National Grid (North Wales Connection Project)

North Wales Connection Project

Document 5.5.2.1 Appendix 5.1 Schedule of Responses to the Scoping Opinion

Final September 2018

Figures 9.2 – 9.3

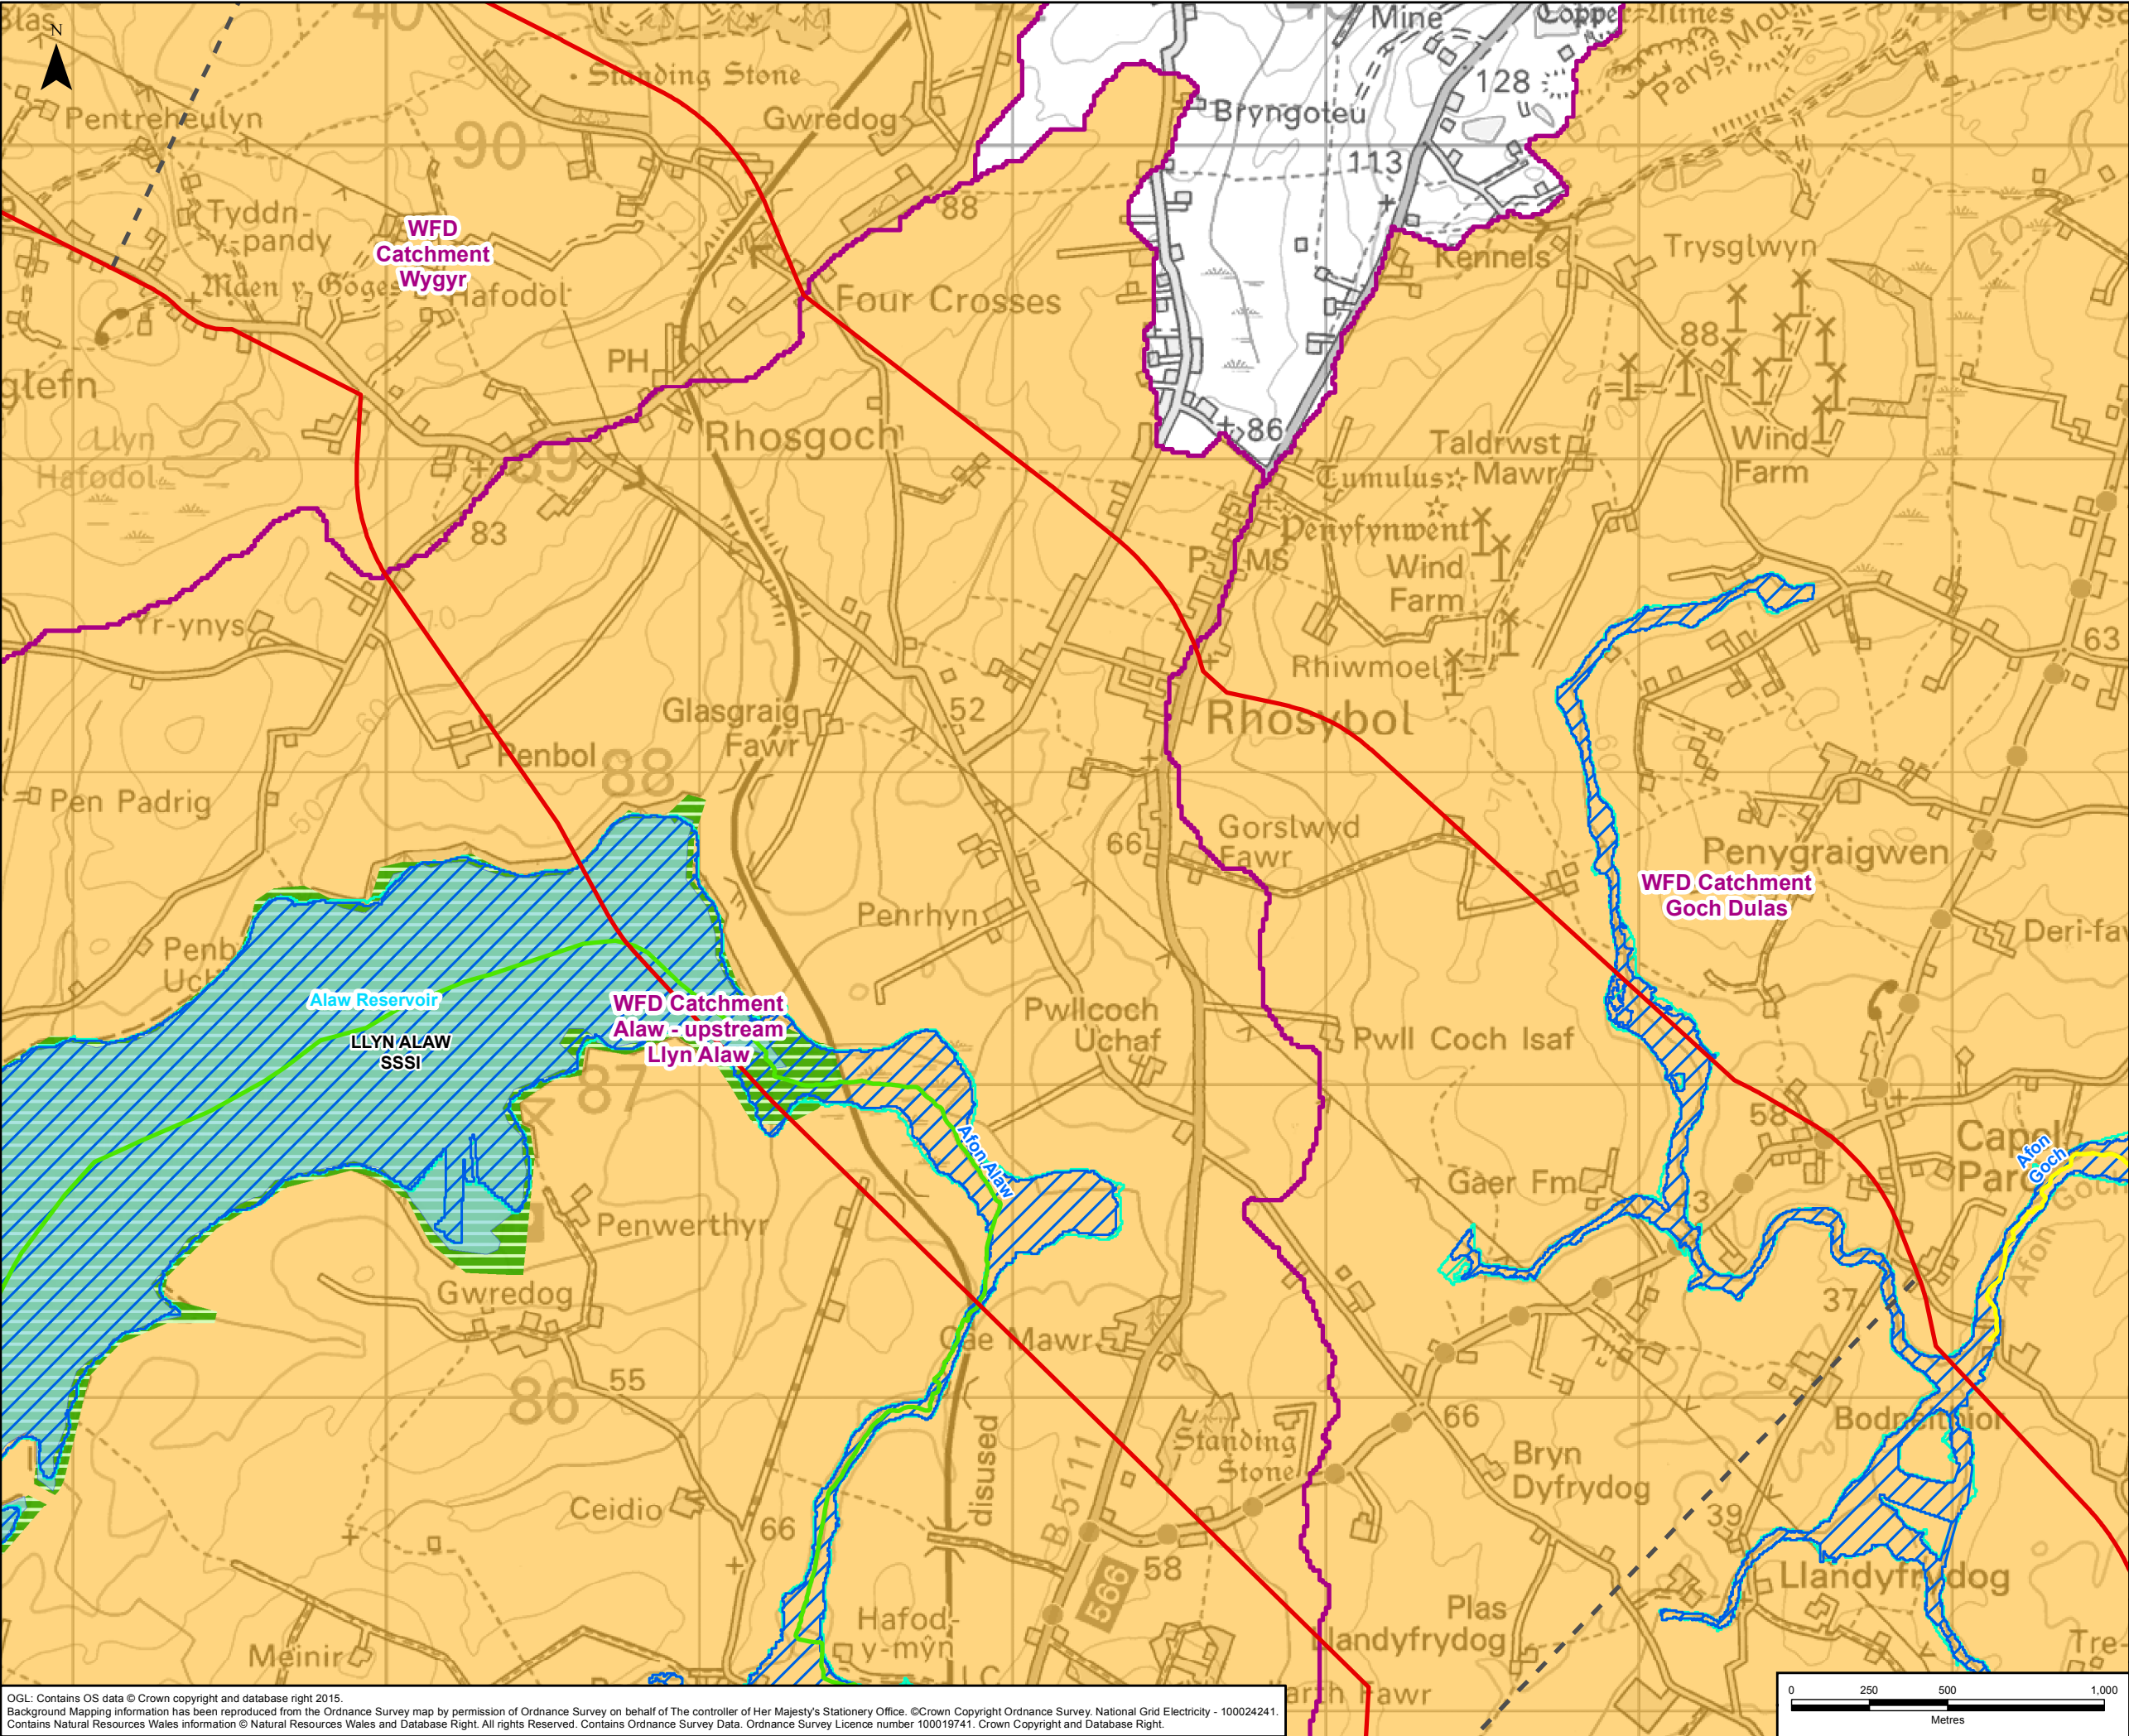
2.16	The Scoping Study Area crosses areas of Flood Zones 1, 2 and 3; these are shown on Figure 9.3 of the Scoping Report.	Flood zones within the study area are set out in Chapter 12 Water Quality, Resources and Flood Risk (Document 5.12) and the Flood Consequences Assessments (Documents 5.12.2.1 to 5.12.2.4).
